Online Comment

Application H16-0542-16
Location 36 Holbeach Road SPALDING PE11 2HQ
Proposal Construction of six two-storey dwellings

PROPOSED SITE PLAN 1:200

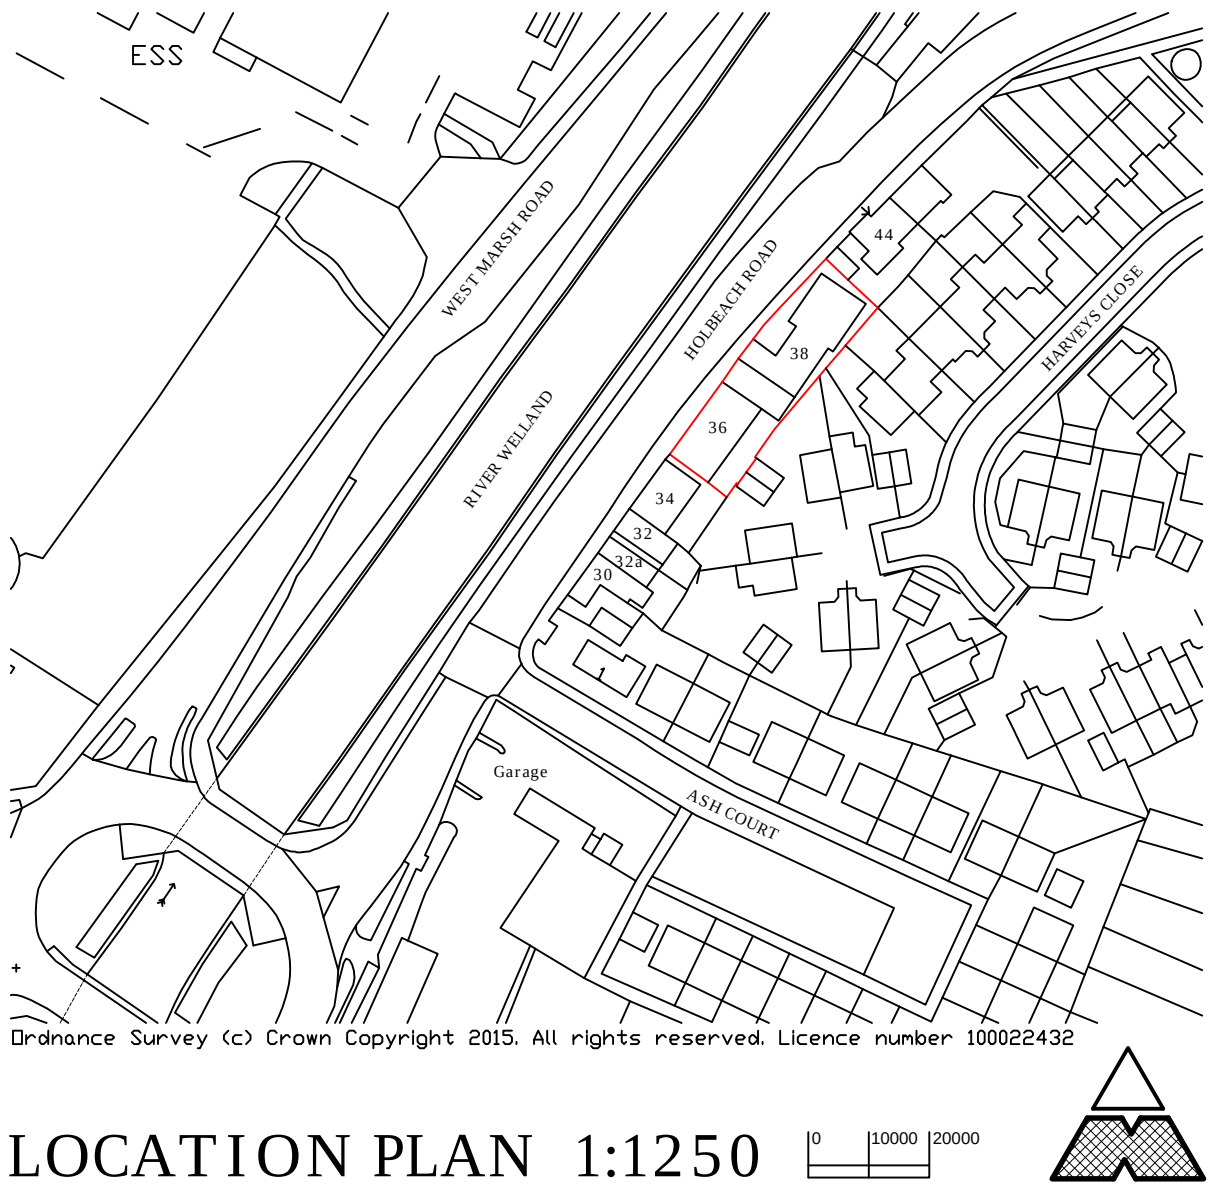
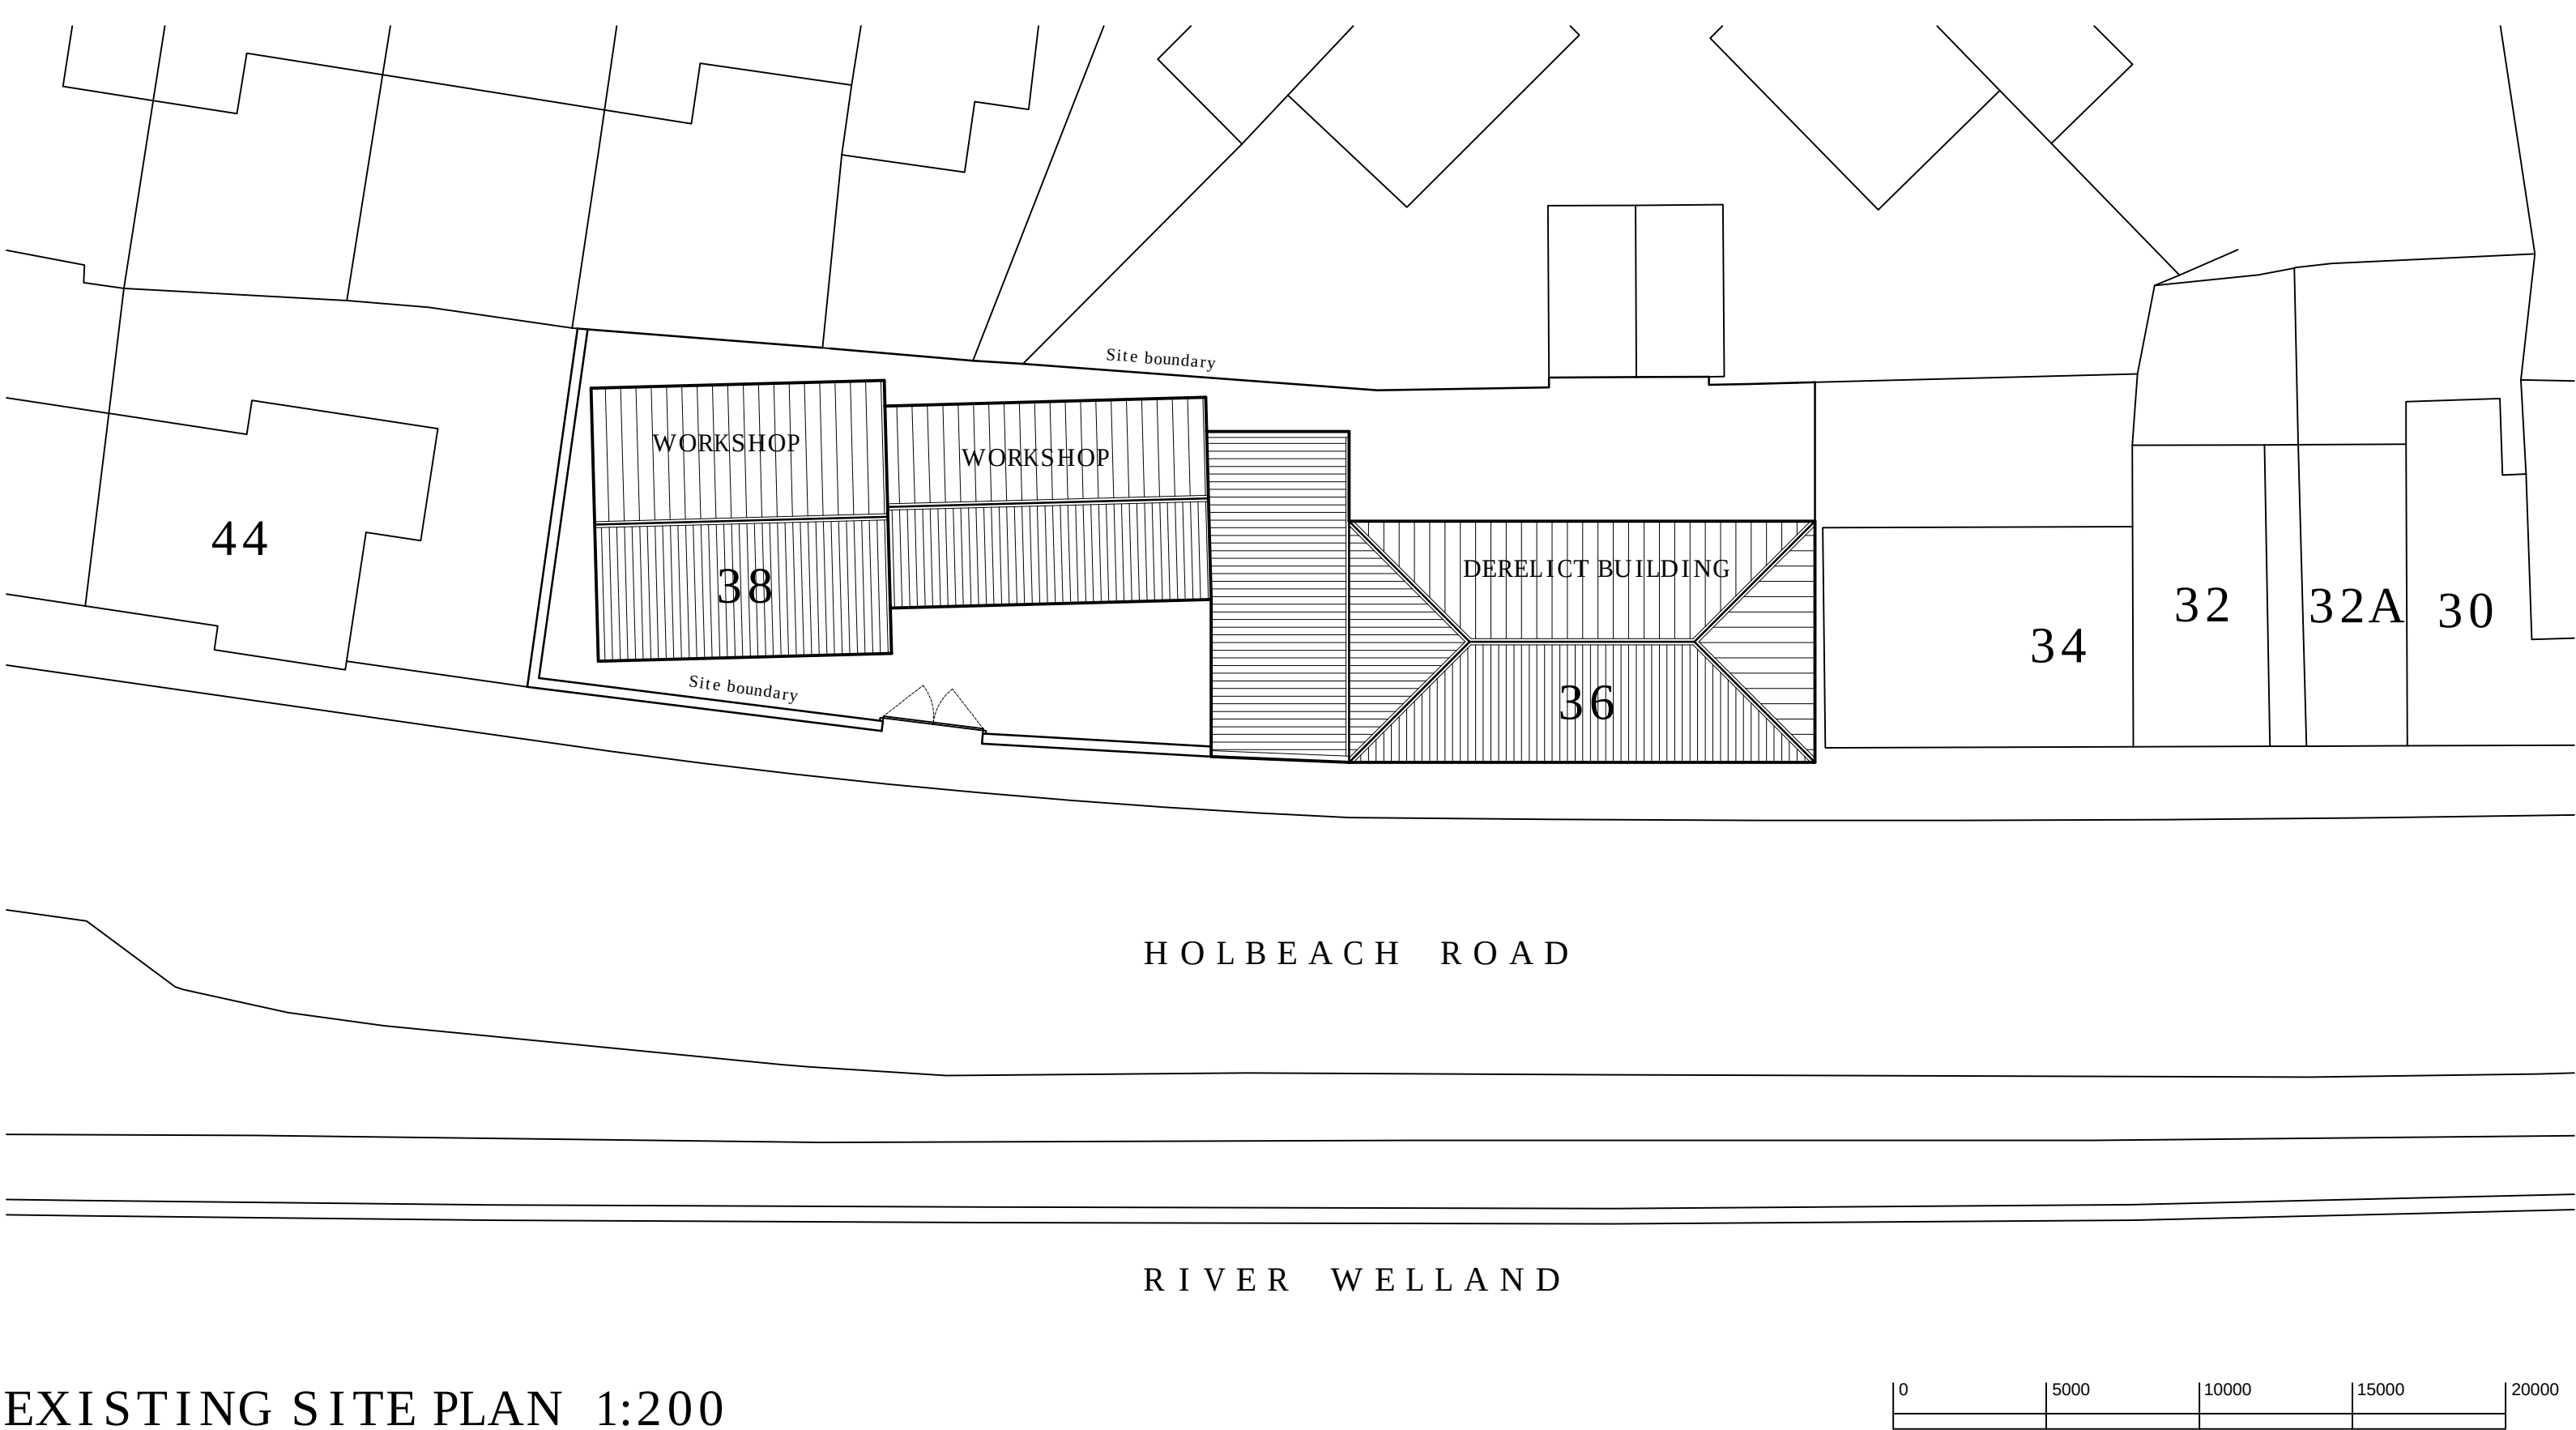
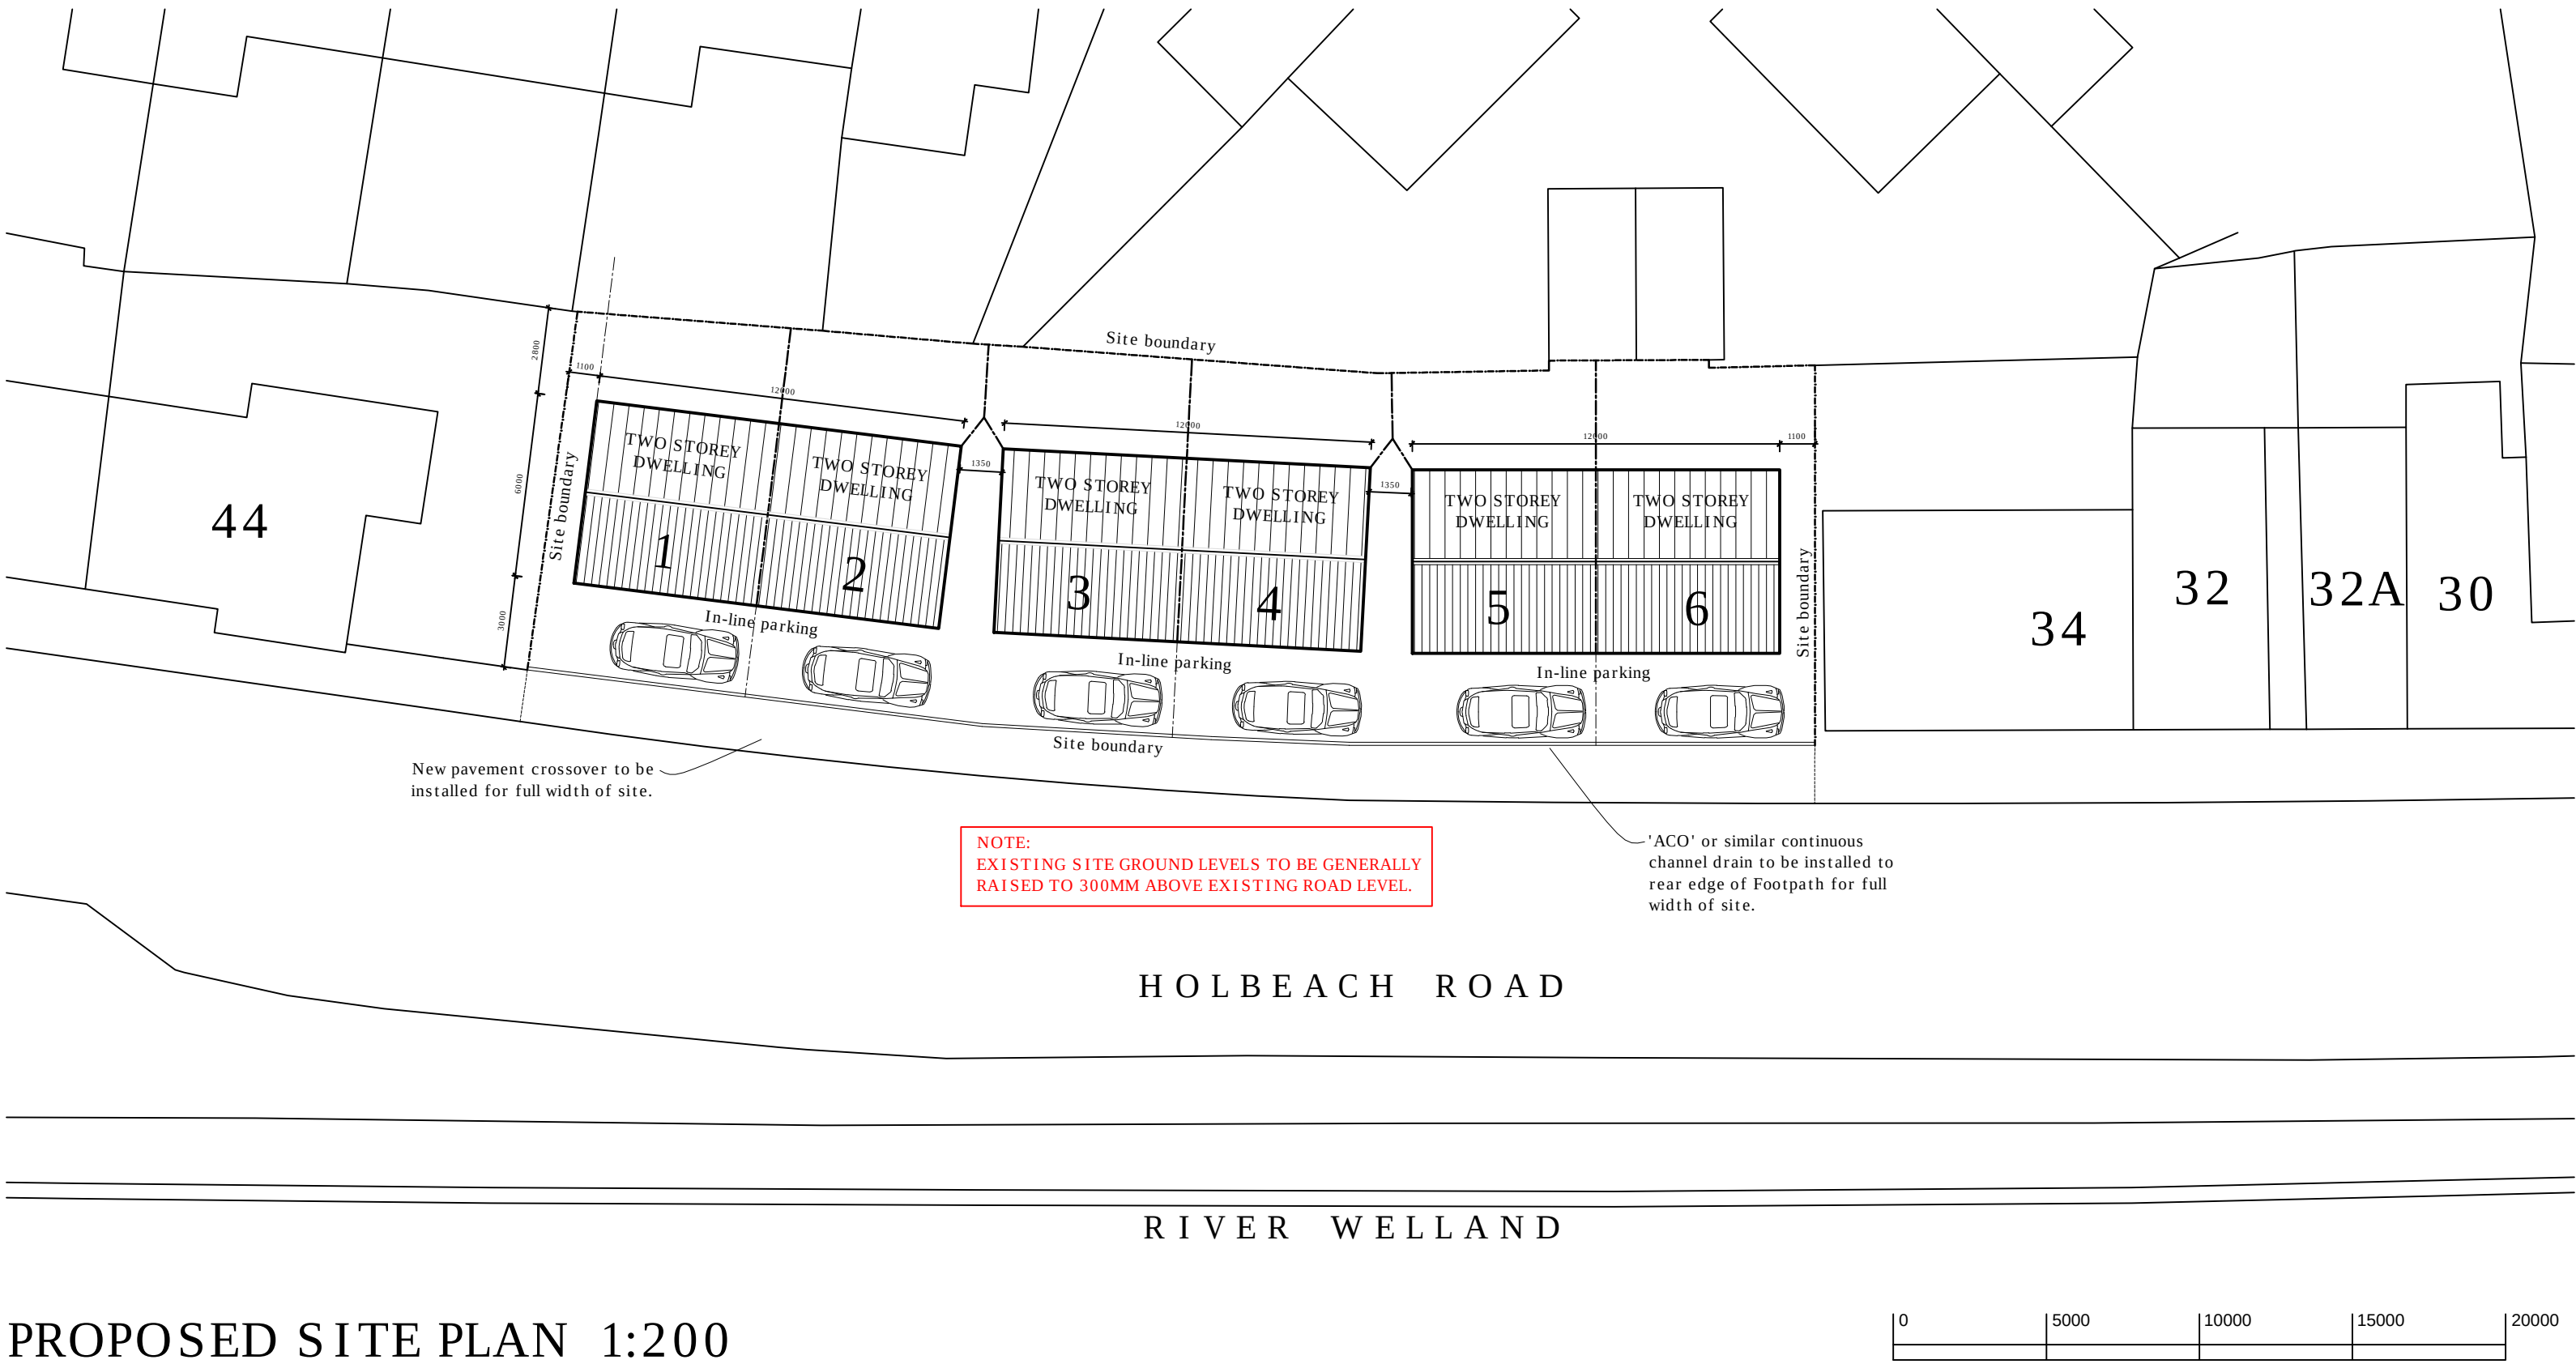
The plans make no provision for storing cycles at each dwelling. Please do not grant permission unless the application is amended to include secure cycle storage for each dwelling to the Council's satisfaction.
